Application for a Non-Material Amendment Following a Grant of Planning Permission

Town and Country Planning Act 1990
Proposed All remaining outstanding matters for plot 2 relating to DM/19/00978/OUT
At 2 Trinity Mews Durham DH1 5GG
For Mr Paul Doran
The above application received on 26 June 2023 was considered by the Council and it has been agreed that permission should be granted. I therefore enclose the appropriate approval certificate. If an application under the Building Regulations was also submitted, development must not commence until Building Regulations Approval has been received from the Building Control Division.

Minor changes to the Front Elevation (South West) window designs and size.

| Title | | Sheet 02 | |

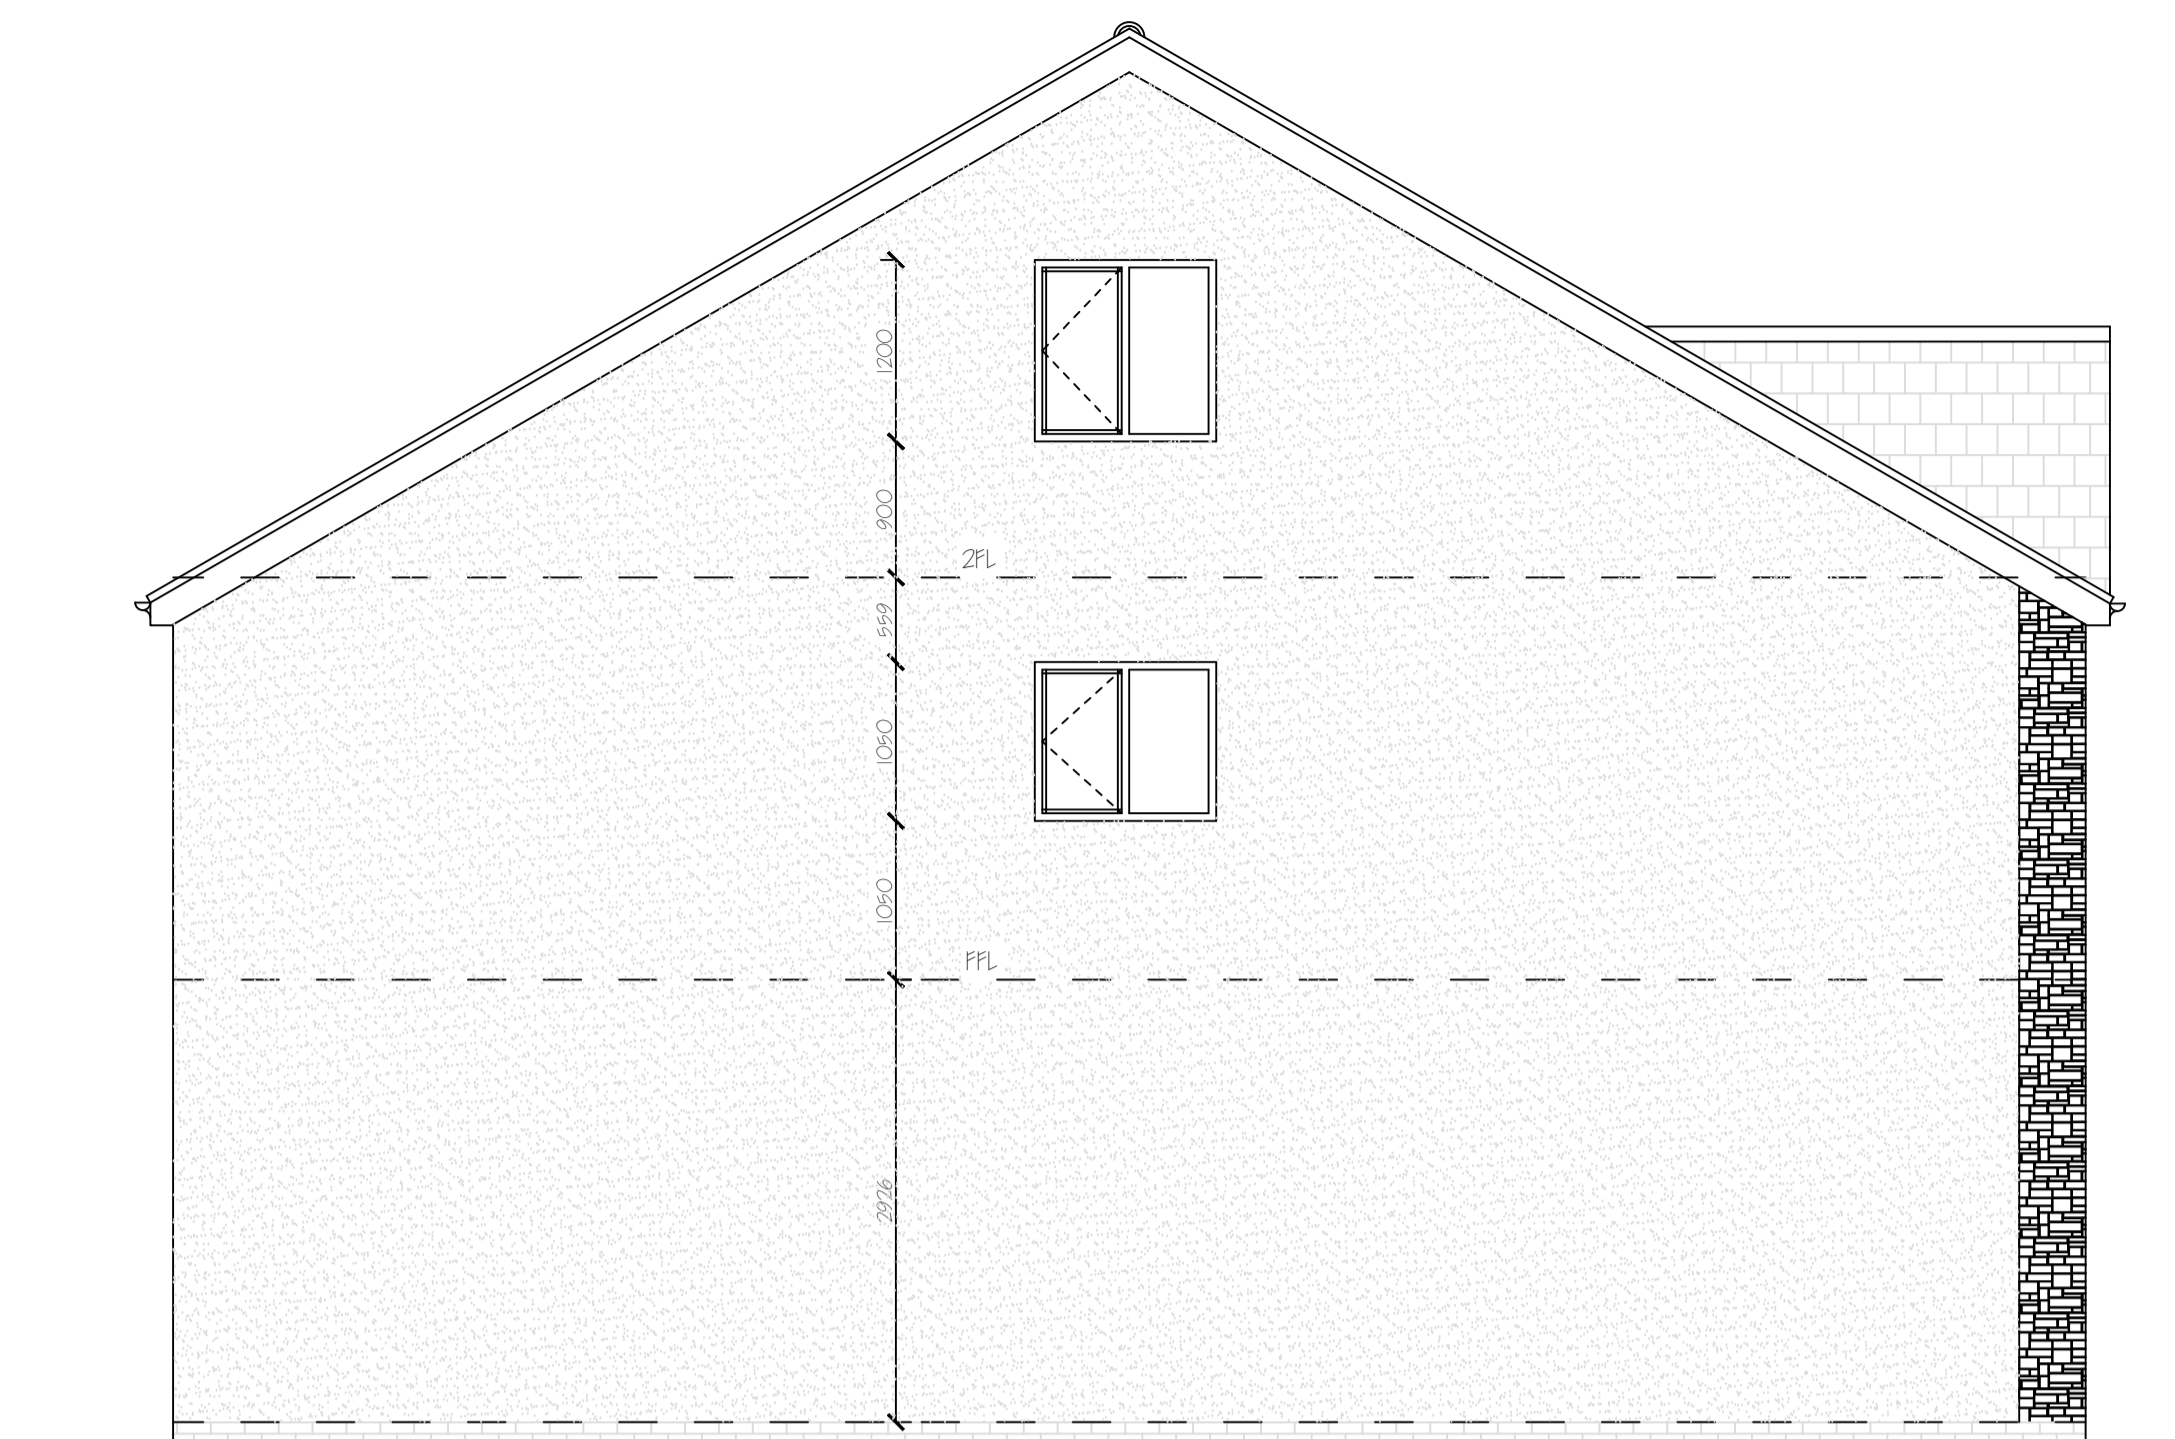
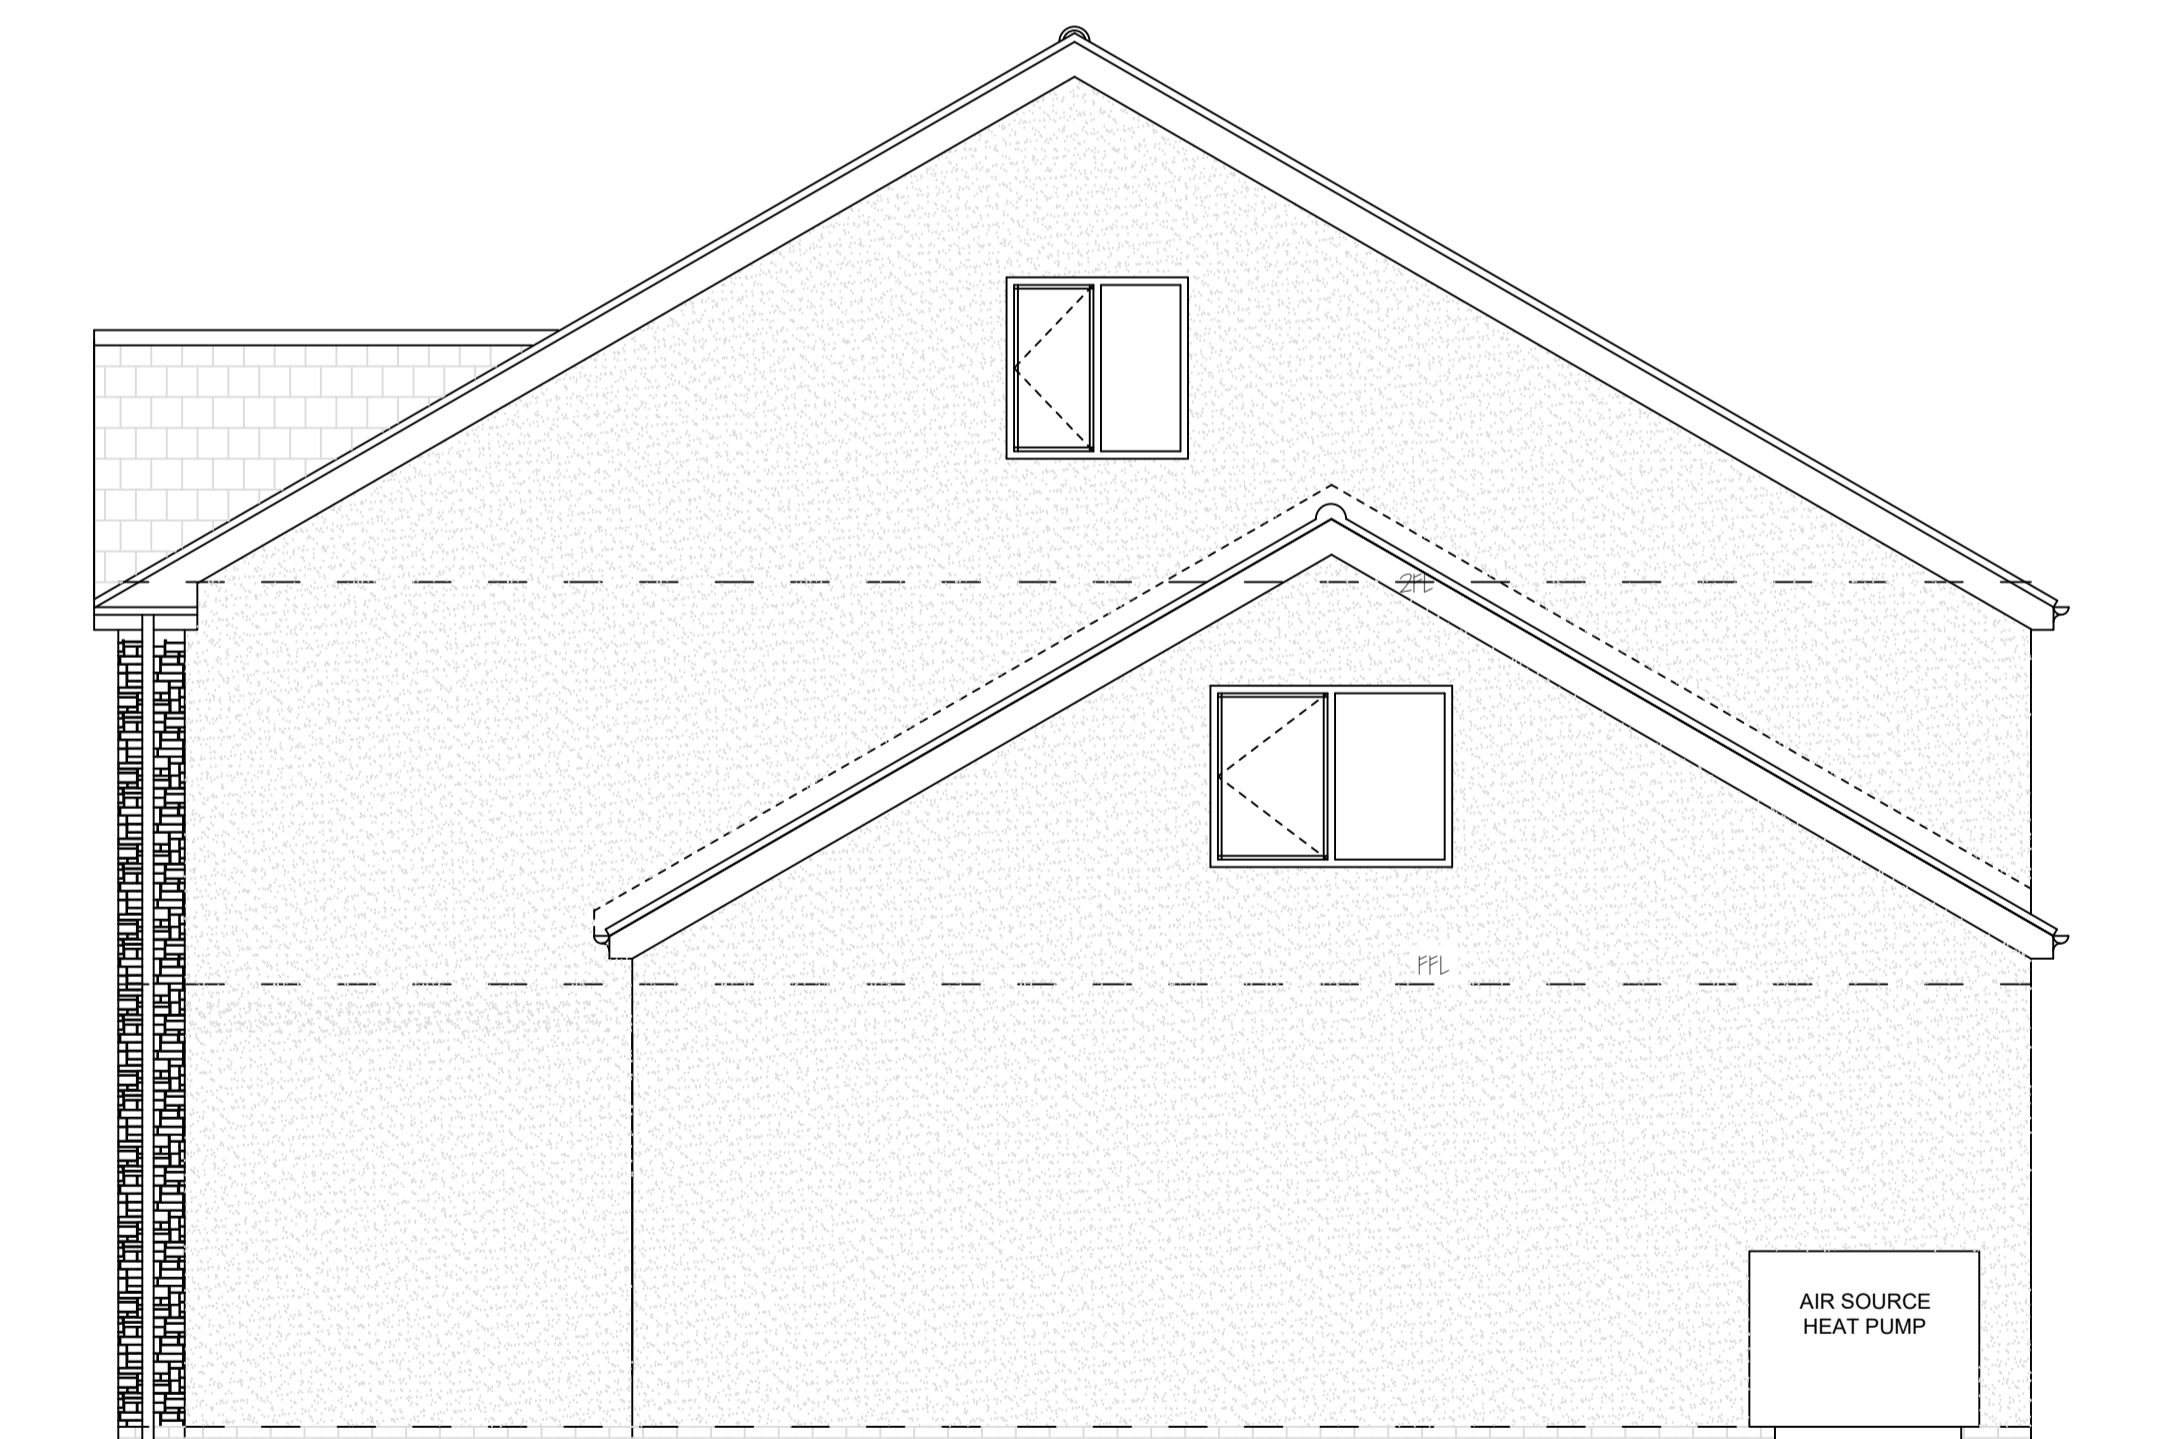
1. Both upstairs bedroom windows to move the bottom of the windows down so that they are close to floor level.
2. Add a Juliet balcony to both bedroom windows.

3. Ground Floor windows also to move the bottom of the windows down so that they are close to floor level.
4. Minor change so that Front door design will be solid door with 1 or 2 side panels.

5. Remove Solar Panels from front garage roof and add in 2 off Velux type windows. (Solar panels on main roof to be circa 8-10 kW in total which is enough for us). Velux windows on rear garage roof to be removed.

6. Remove 2 off uppermost windows on Gable Elevations, North West and South East facing.
7. Remove External rear door into Plant Room. External Rear door to Utility to remain.

8. Update to external finishes - Windows to be Thermally Broken Aluminium (Anthracite) and not uPVC, Driveway to now be Permeable Block Paving and not Tarmac and Roof tiling to be Natural Slate and not Marley Modern Concrete tiles.
